Markup Summary

CHRISTIAN BROTHERS AUTOMOTIVE - FALCON
LEGEND

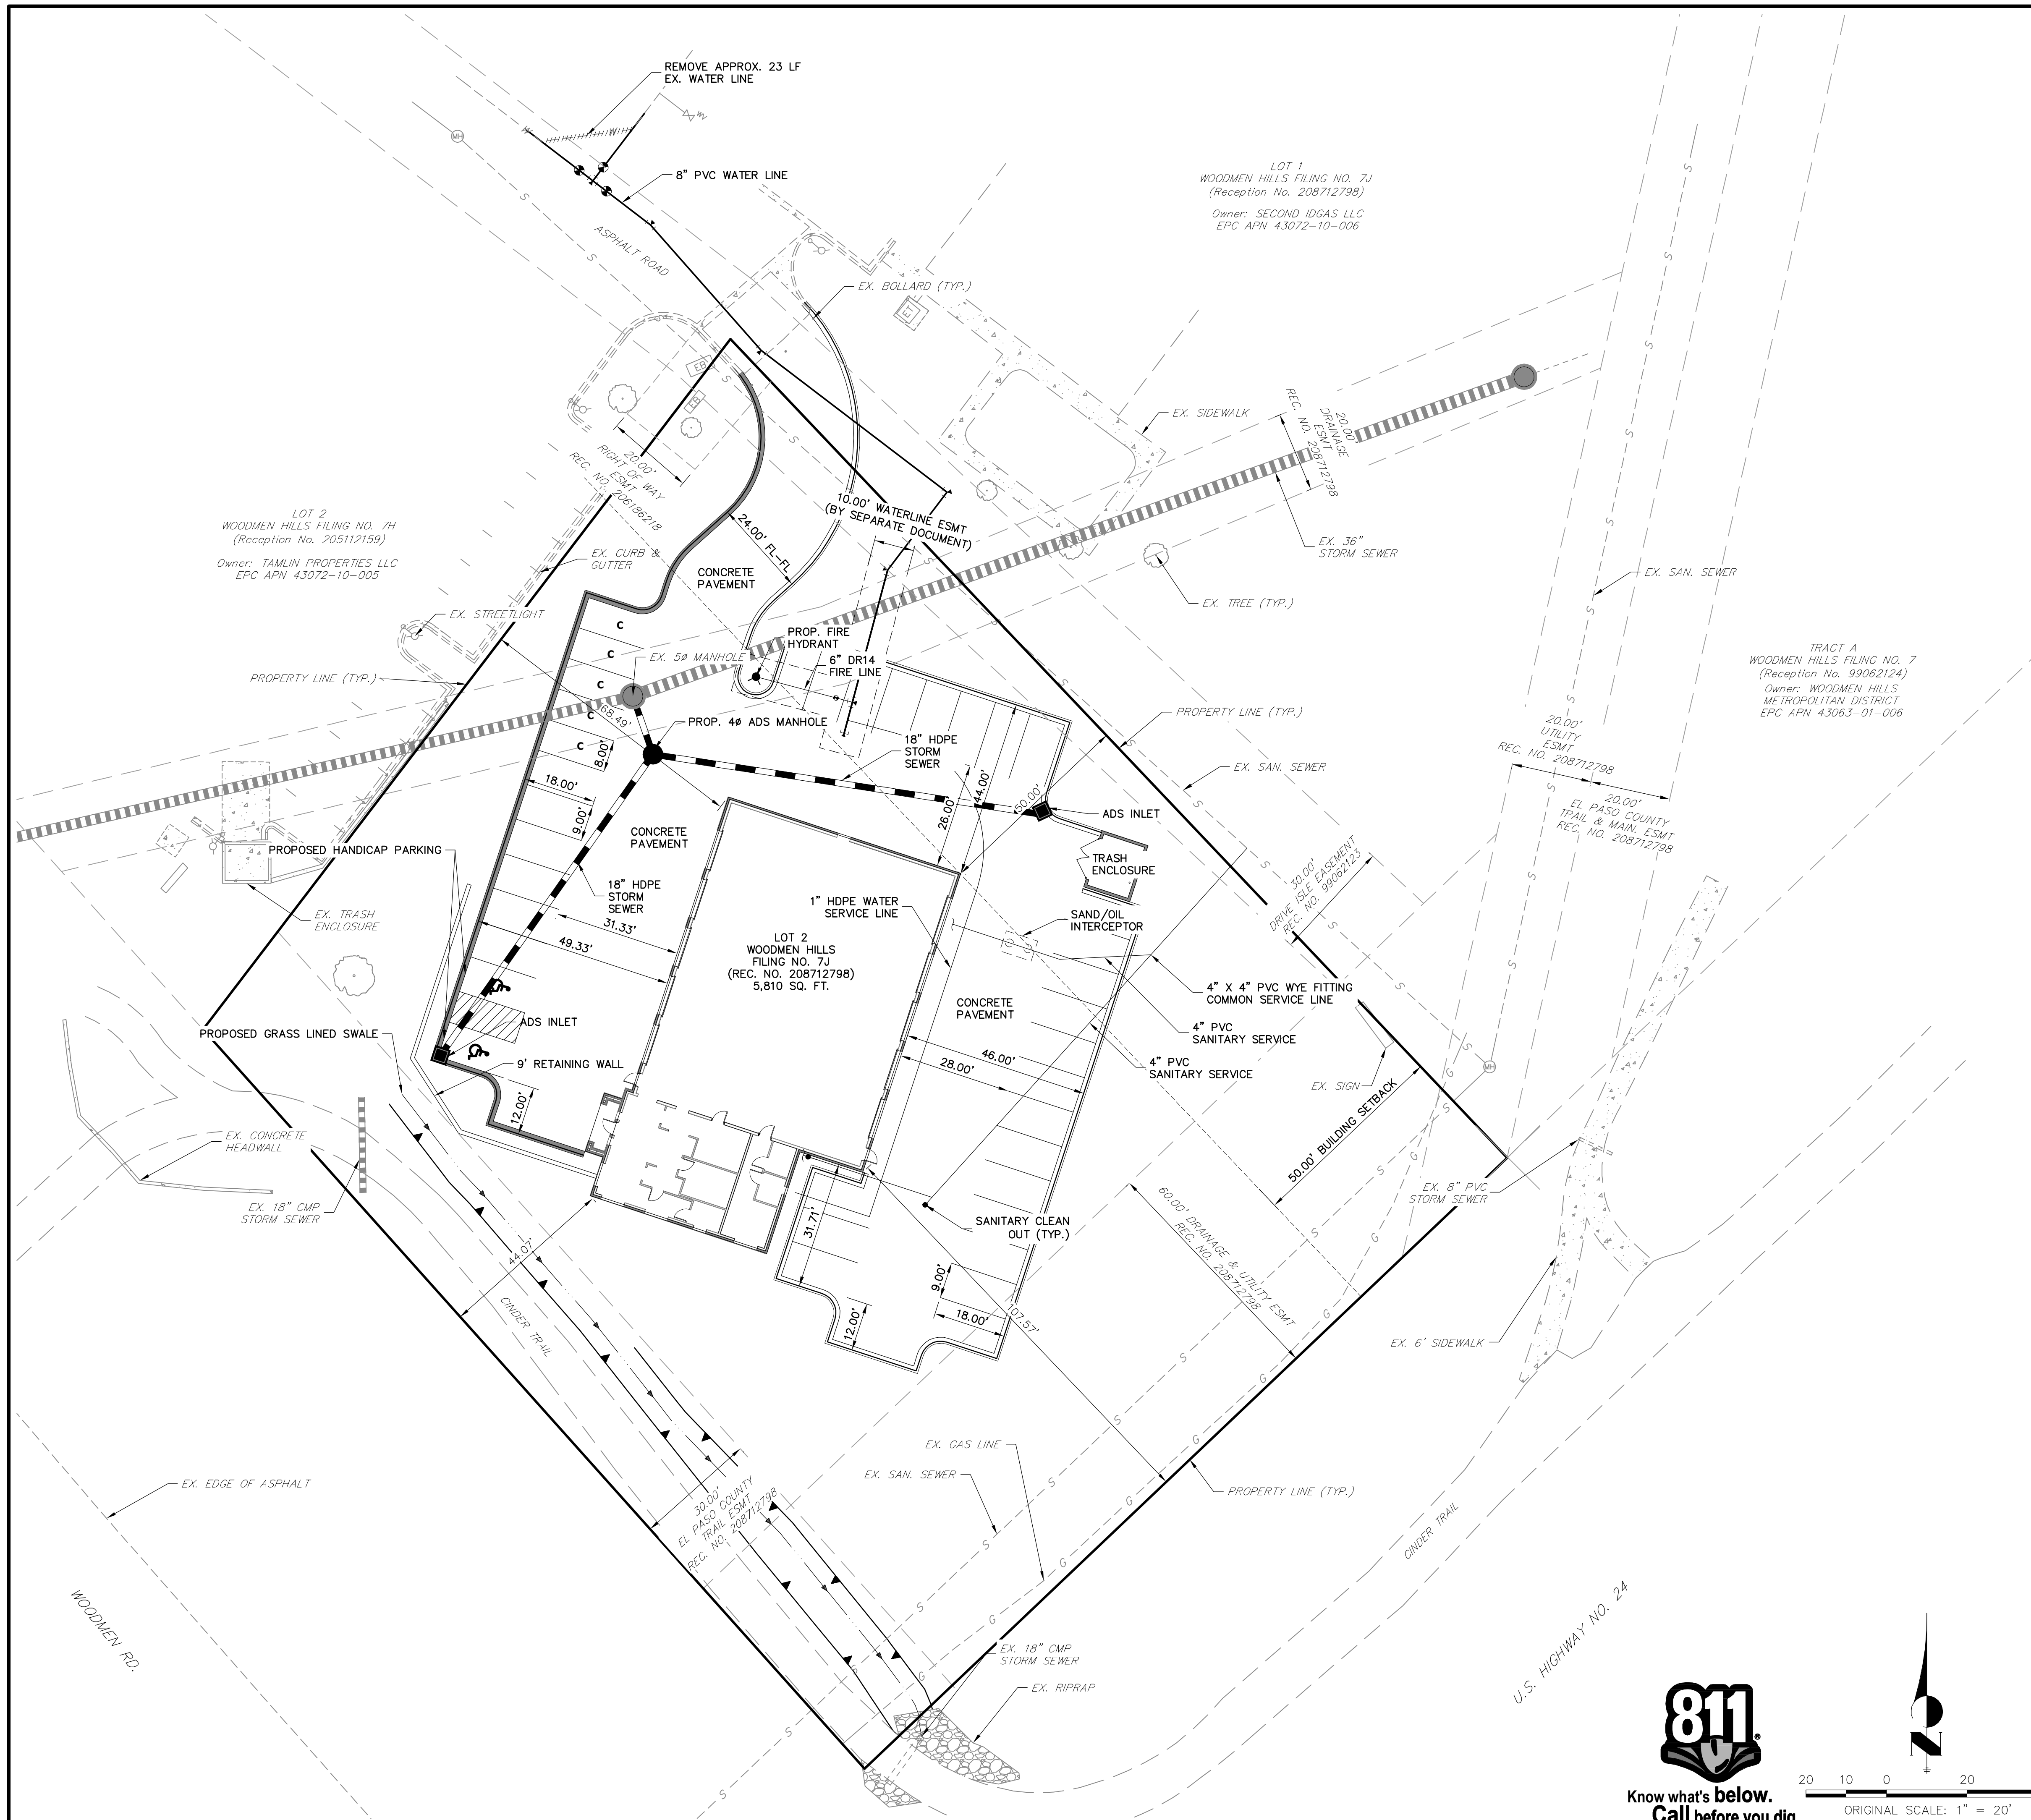
Provide a note that all roof drains will drain to paved areas and/or storm drains.

(possible grass swale per EPC Parks comments?)

Revise per Planning comments regarding ADA requirements and sidewalk connections.
